25 September 2013

**330 Church Street Parramatta
Response to DoPI letter Ref MP10_0171 MOD 3**

TCA responds to the relevant architectural and urban design items raised in your preliminary assessment letter and as discussed during the meeting on the 20th September 2013 as follows:

ELEVATIONS -
PODIUM

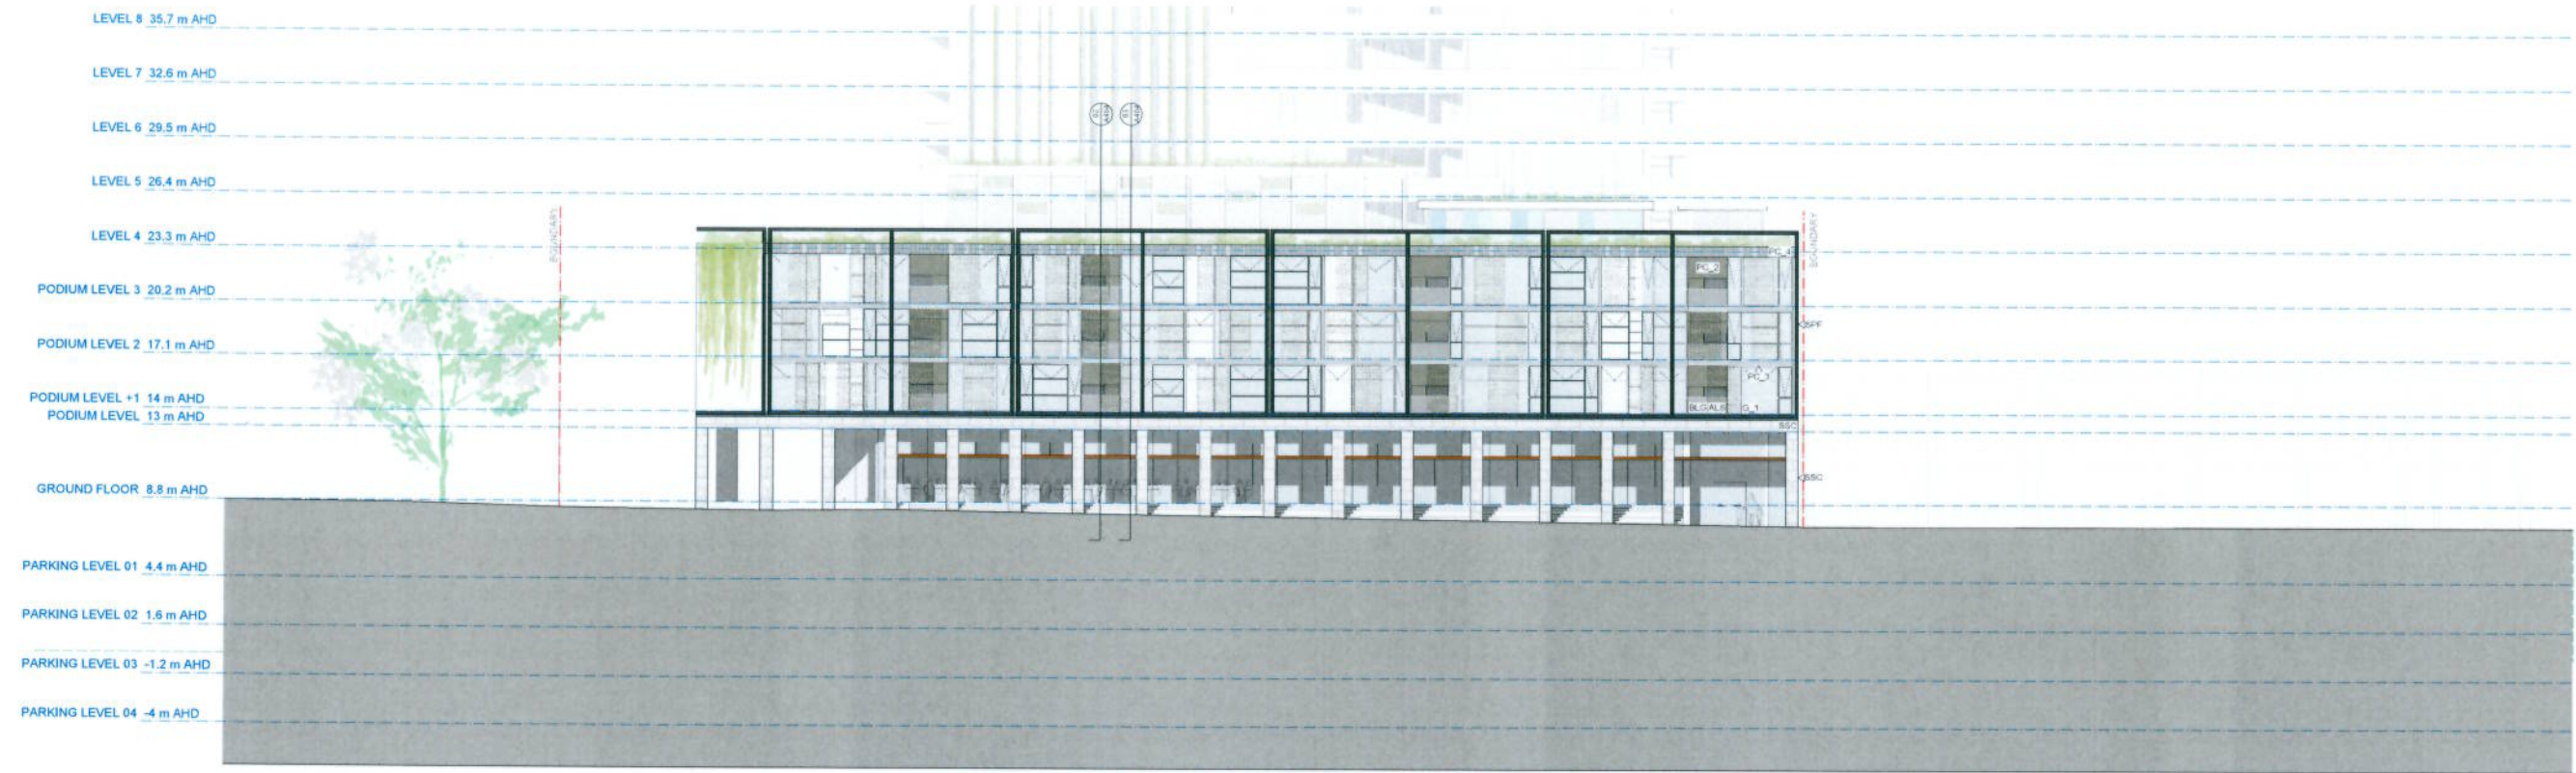
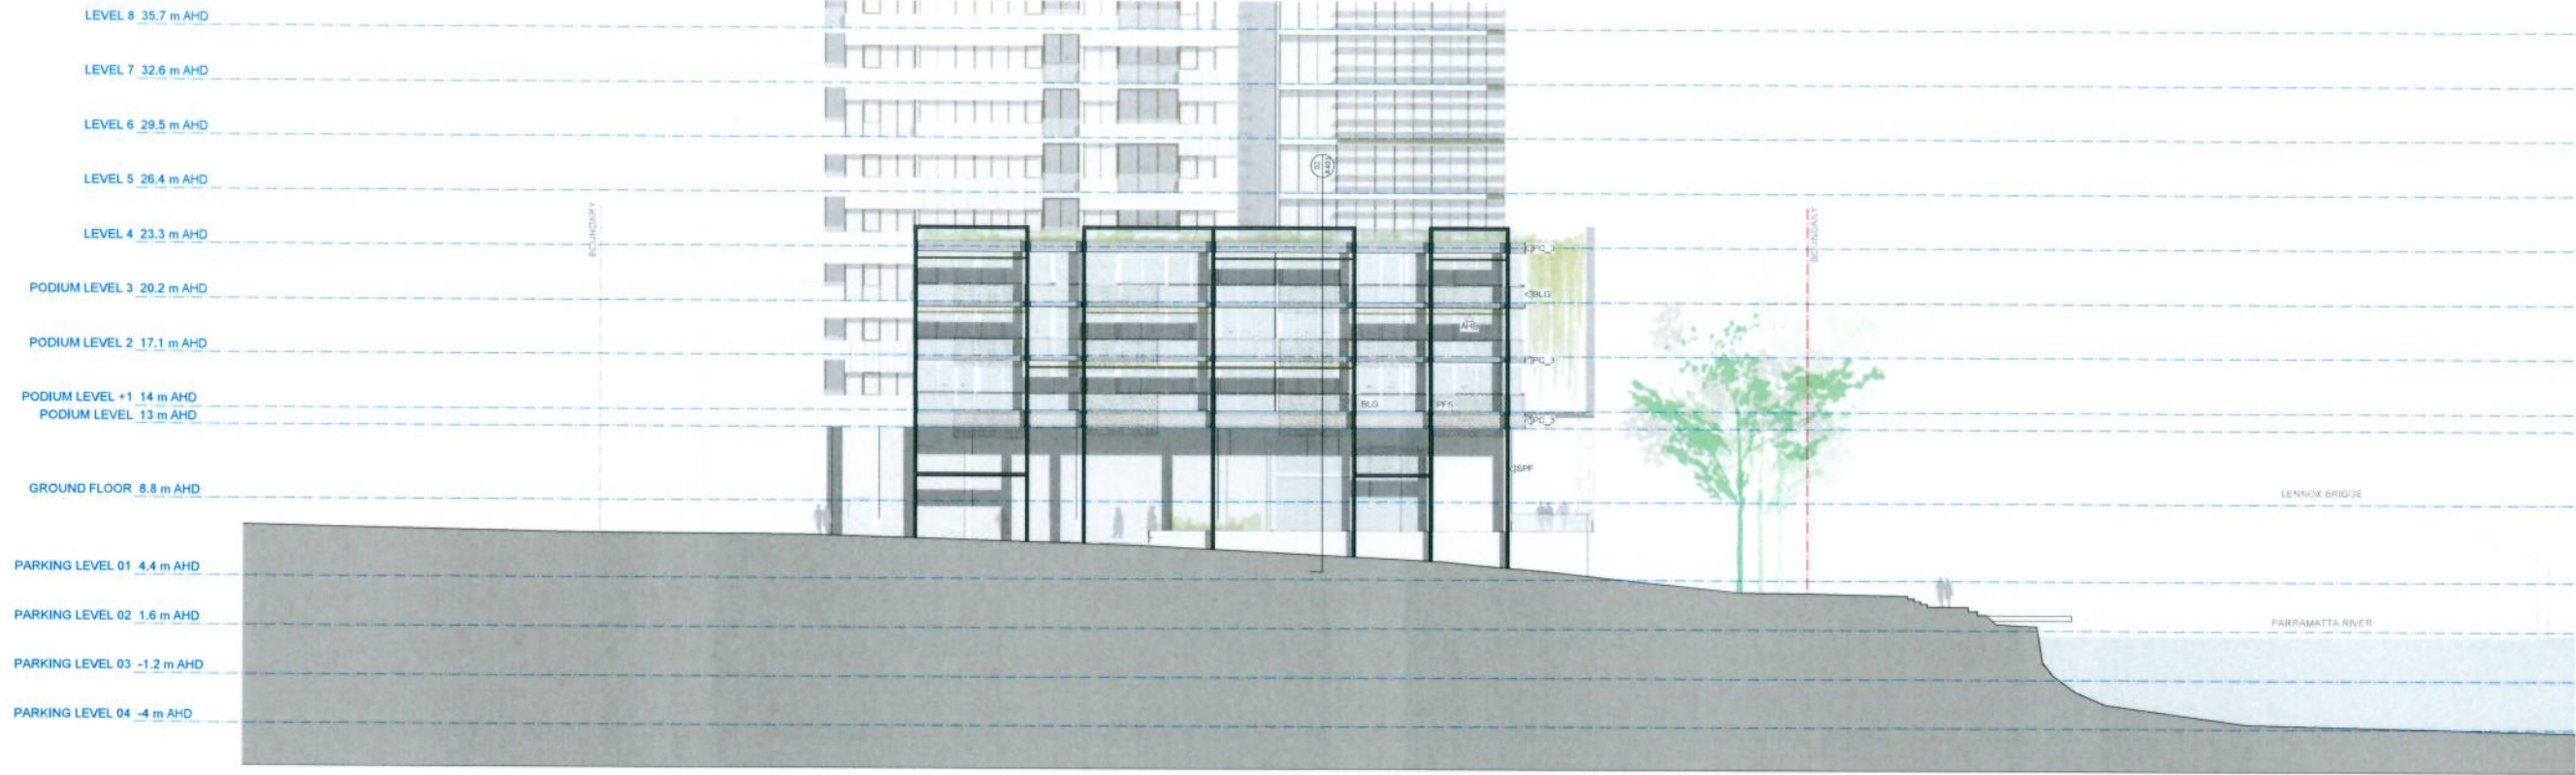
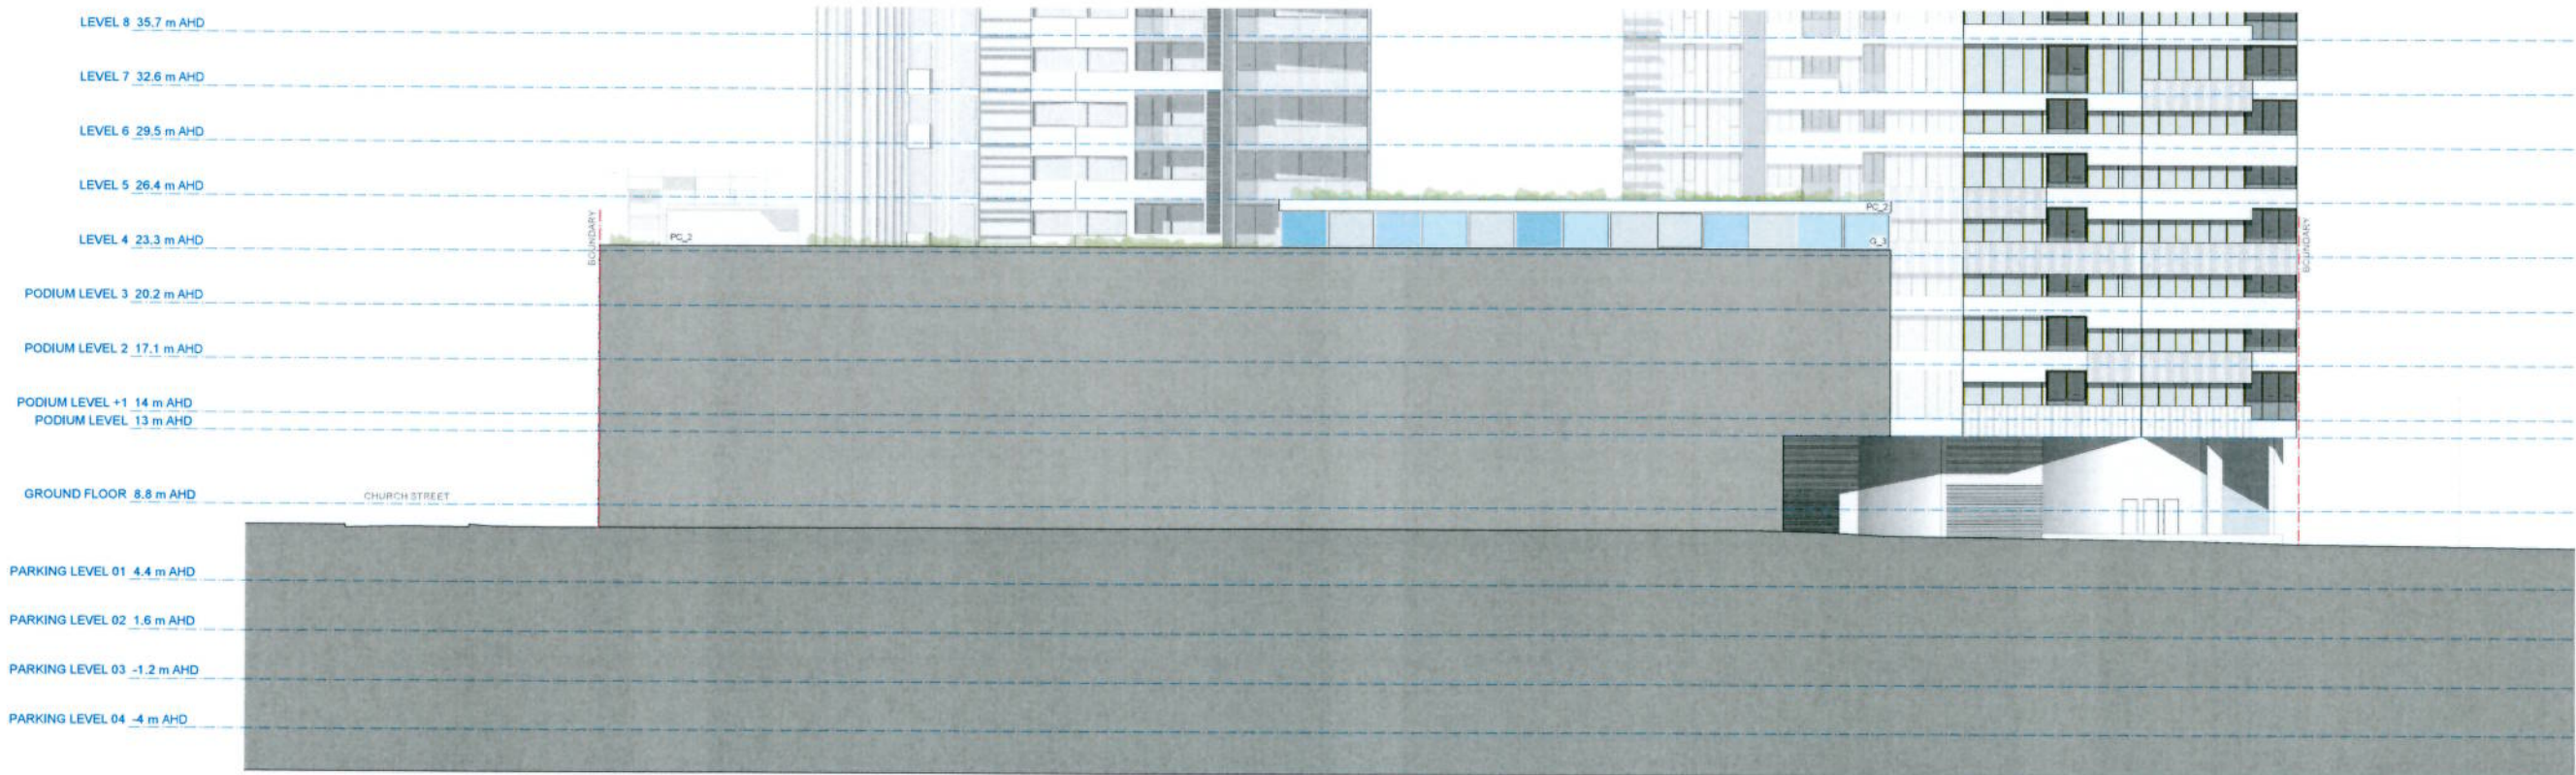
Podium Design

The steps are an appropriate response to address flood levels and to activate Church street. The connection to the high point of the site at the northern end of the steps also provides universal access to the Church street retail premises.

The drawings have been amended to increase the glazing break up to more appropriately scaled proportions. The final breakup of the retail spaces will be subject to future tenancies.

The drawings have been amended to mitigate the impact of the pool building on the Church Street frontage. The landscape buffer has now been increased and the setback increased.
